From: Peter Cleveland <[REDACTED]>
Sent: 24 August 2022 08:37
To: Simon Davis
Cc: James Snelgar; David Linton-Clowes ([REDACTED]); Emily Raine
Subject: RE: Y/53/22/DOC

*The construction does not appear to have been carried out in accordance with the design, in addition there are still elements of the construction which are wholly reliant on the contractor's information rather than an independent verifier. As a result, **we would not recommend Discharge of Conditions** until the following information has been provided and following points have been addressed and approved in full.*

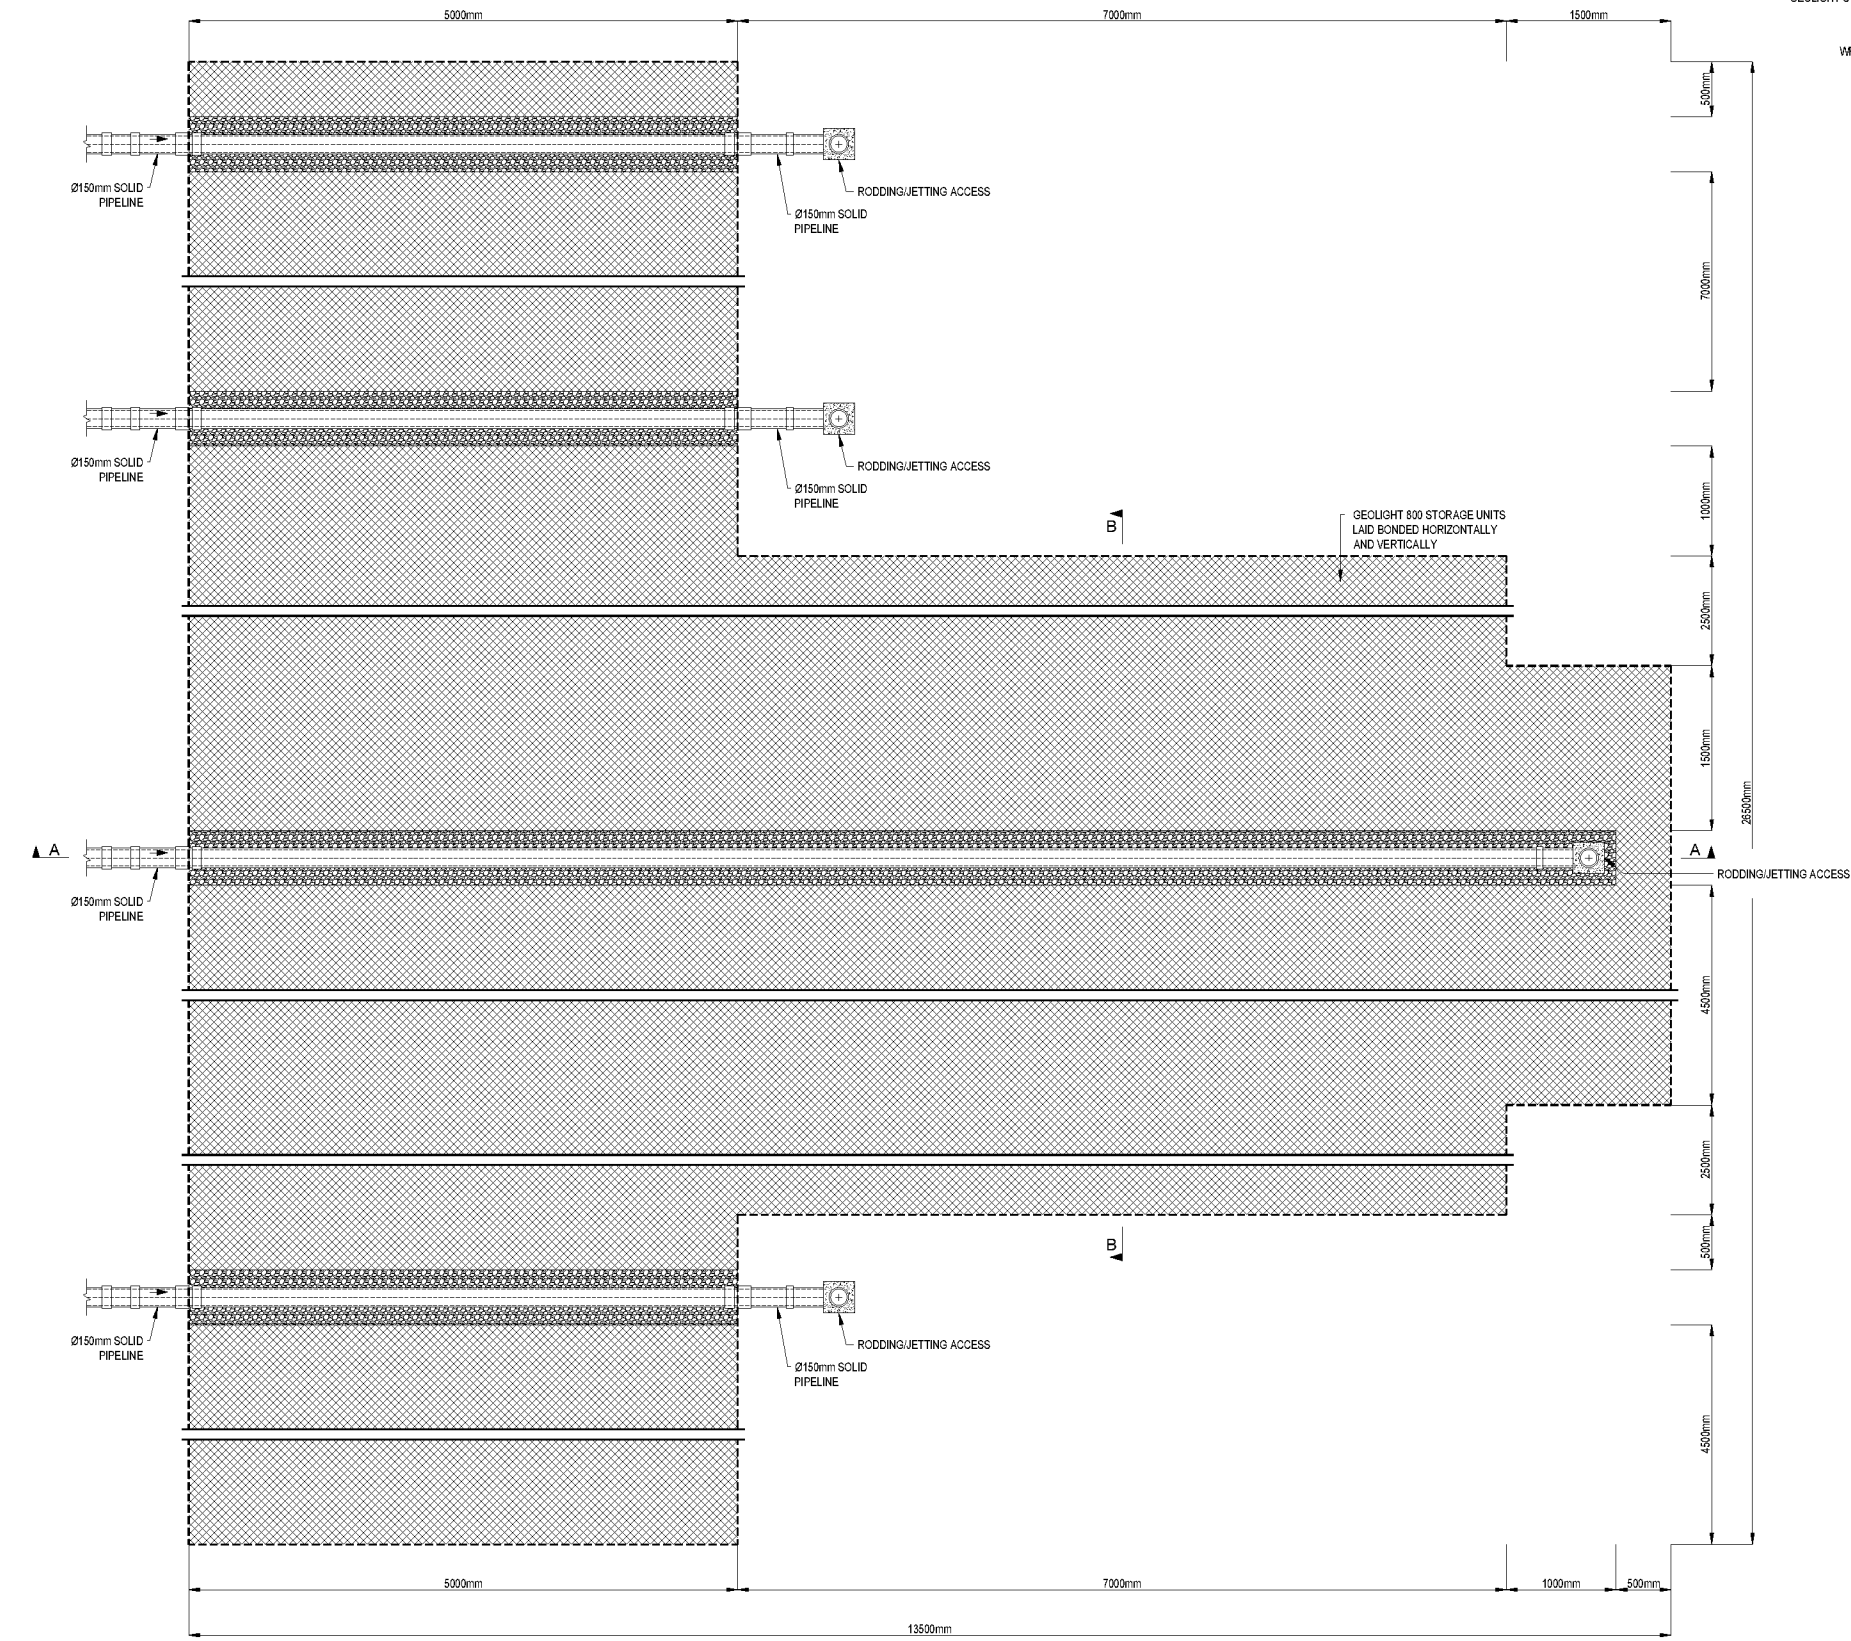
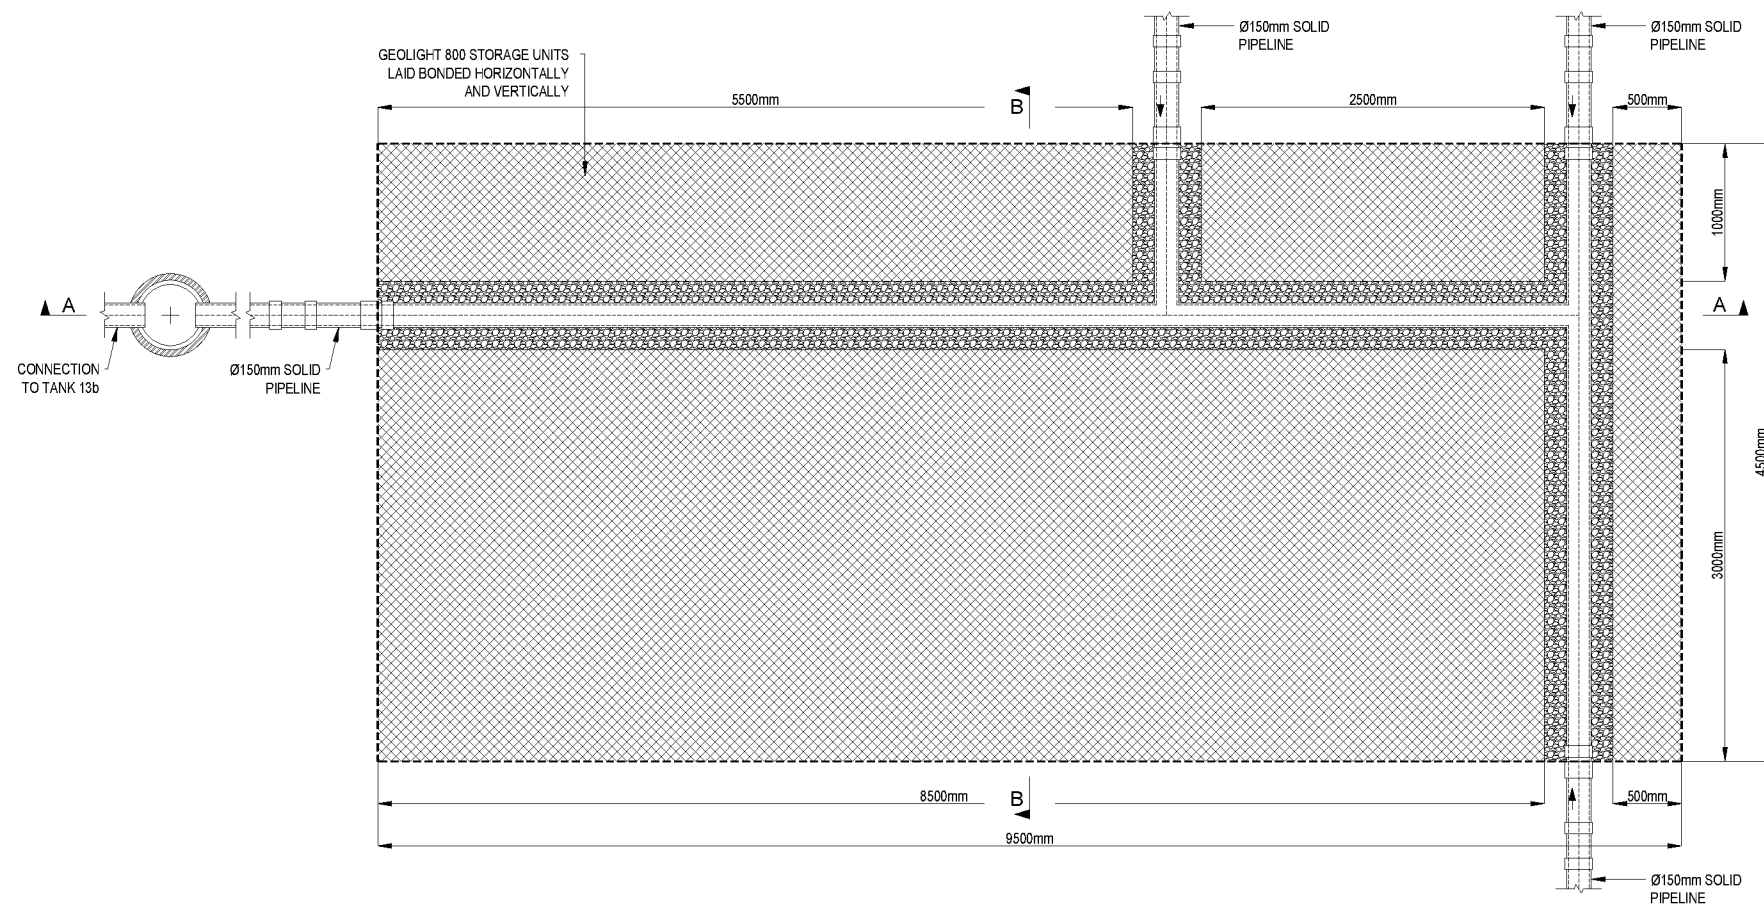
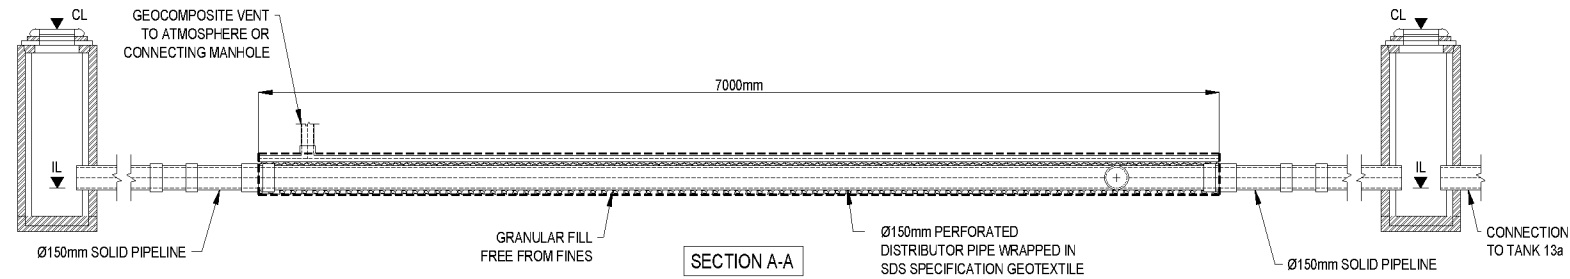
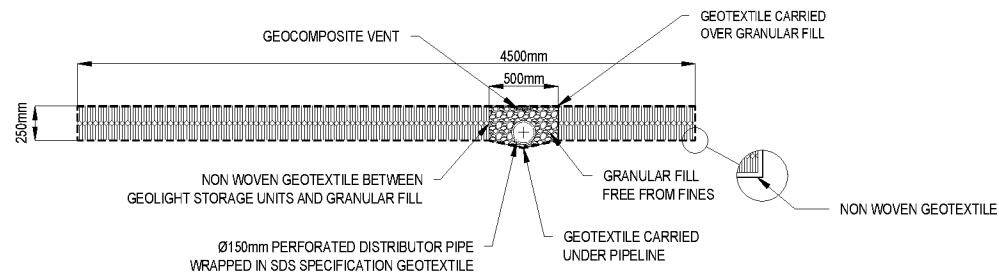
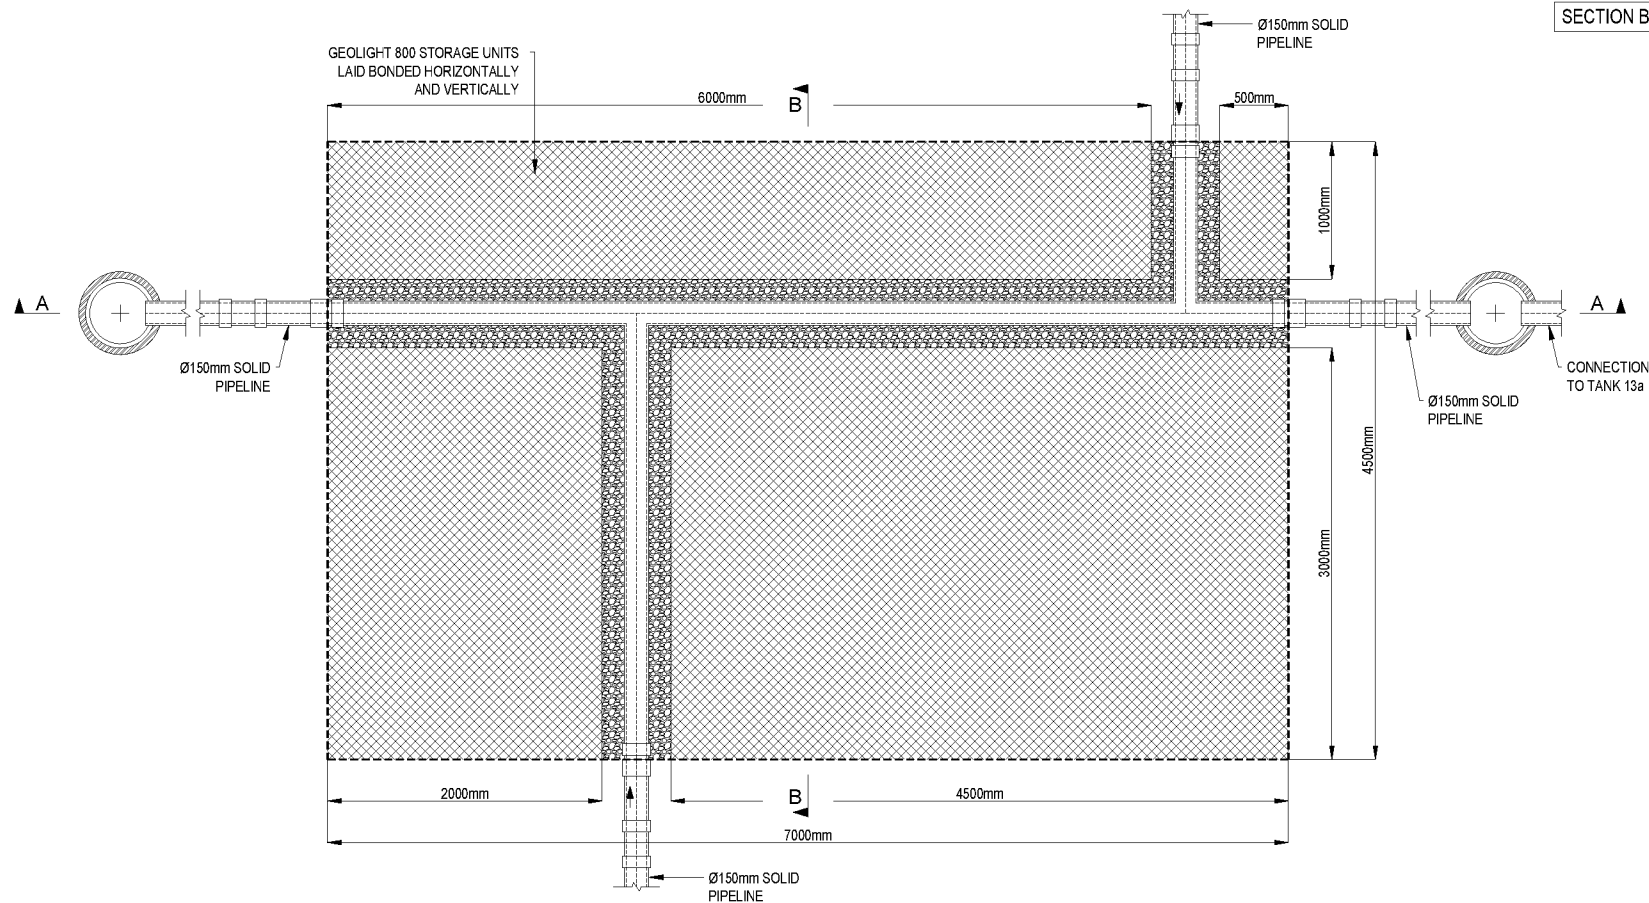
- Checking and remediation of the poorly constructed sediment traps (assuming they are installed as photographed). The sediment traps should be installed as per the submitted drawings. These photographs show several defects in construction including square cut outs used to house round pipes, cracked rims and plastic, the use of unapproved materials within their construction, rubble filling the base (which visually cannot be confirmed to have been lined) and concrete which appears to have been used as a sealant and is partially blocking one pipe outlet. None of this appears on any of the approved drawings.*

- A proposal for remediating these issues should be submitted.*
- 4) The letter submitted detailing all of the drawings refers to YAP-180-31 REV C4 however, the submitted planning drawing is Revision C5. The applicant will need to confirm which drawing the contractor was working off and confirm that the scheme was not constructed to an earlier design.*

3. The photo evidence shows the inclusion of the crates and doesn't show a finished product which would have been corrected as completed. The letter mentioned above would give clarification of this.
